OBSERVATION/SUBMISSION TO PLANNING APPLICATION

Case Reference: 324113

Re: Observation to the proposed development of open-cycle gas turbine (OCGT) and generator with ancillary equipment.

Location: Pollnagroagh and Rathmorrissy (Townlands), Athenry, Co. Galway

Purpose		PLANNING			
Title		SITE ACCESS SIGHTLINES			
Original Scale	Design/Drawn	Checked	Authorised		
SHOWN at A1	PS	ND	AJB		
Date	Date	Date	Date		
01.12.25	01.12.25	01.12.25	01.12.25		
Status	Drawing Number	Rev			
A2	PEK3-ATK-ZZ-01-DR-CE-901200	0

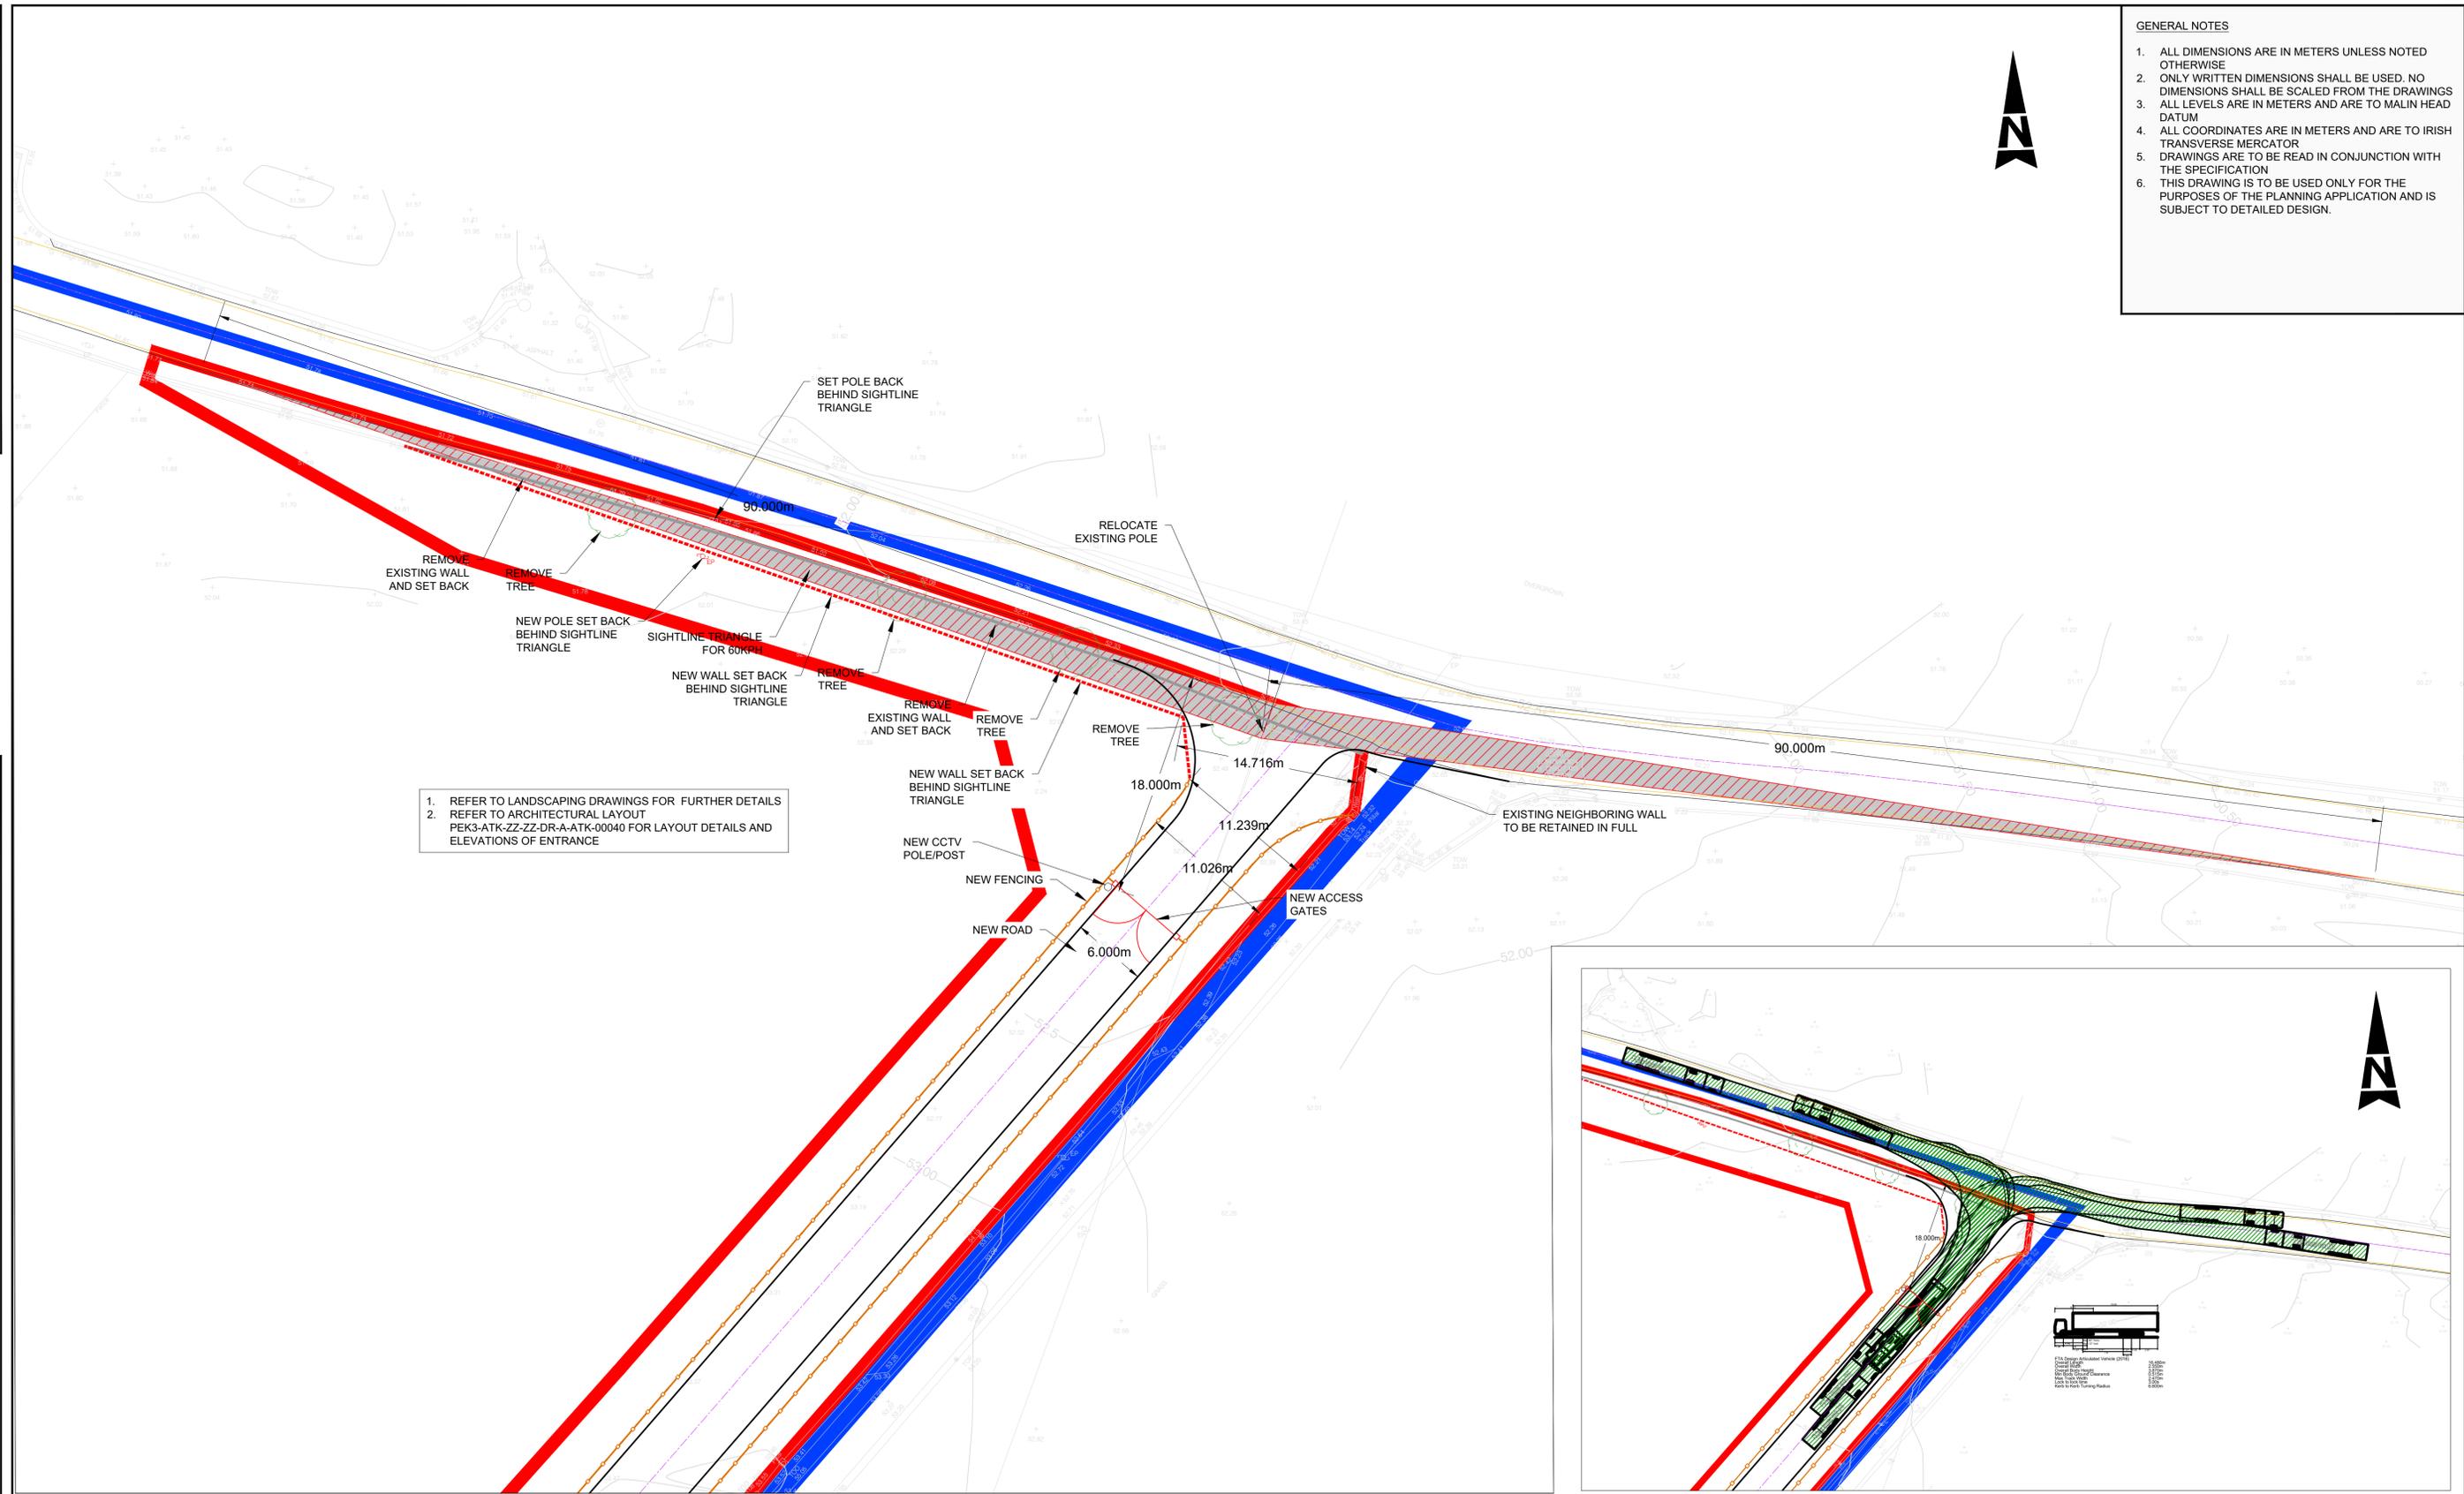
proposed entrance on the L3103. This stretch of road is already extremely narrow, with no hard shoulder, making it difficult for two heavy goods vehicles to pass safely and leaving no margin for error. Visibility is also poor due to blind dips and sharp bends, meaning drivers often cannot see oncoming traffic in time. The proposed development would increase traffic levels, including heavy goods vehicles, construction traffic, and fuel deliveries such as diesel tankers, all of which require space and clear sightlines that this road does not provide.

As someone who lives locally and extensively uses this road, I am concerned about the proposed location of the site entrance on the L3103. This section of road is already extremely dangerous, as it is narrow, has no hard shoulder, and does not provide sufficient space for two heavy goods vehicles to pass safely. Visibility is also poor due to blind dips and sharp bends, meaning drivers often cannot see oncoming traffic in time, and introducing a site entrance at this location would significantly increase the risk to all road users.

There are serious concerns about the proposed site entrance on the L3103, which is an exceptionally dangerous stretch of road where introducing an access point would create an unacceptable level of risk. The road is extremely narrow and cannot safely accommodate two heavy goods vehicles passing at the same time, there is no hard shoulder to allow for safe manoeuvring or recovery, and visibility is severely limited due to blind dips and sharp corners. These are significant existing hazards that already pose a real danger to road users, and the addition of a site entrance would further increase that risk.

The placement of a site entrance at this hazardous location on the L3103 raises serious safety concerns. The road is already constrained by its narrow width, the absence of a hard shoulder, and extremely poor visibility due to blind dips and sharp corners, yet the Environmental Impact Assessment does not appear to fully address the safety implications of introducing an access point at this location. There are also concerns that the cumulative impact of additional traffic has not been properly assessed, including construction traffic, ongoing operational traffic, and fuel deliveries, and the interaction between heavy goods vehicles and existing road users—such as local traffic, school-related movements, and agricultural machinery—has not been examined in sufficient detail. Overall, the lack of a thorough and robust traffic safety assessment creates significant uncertainty as to whether the local road network can safely accommodate this development.
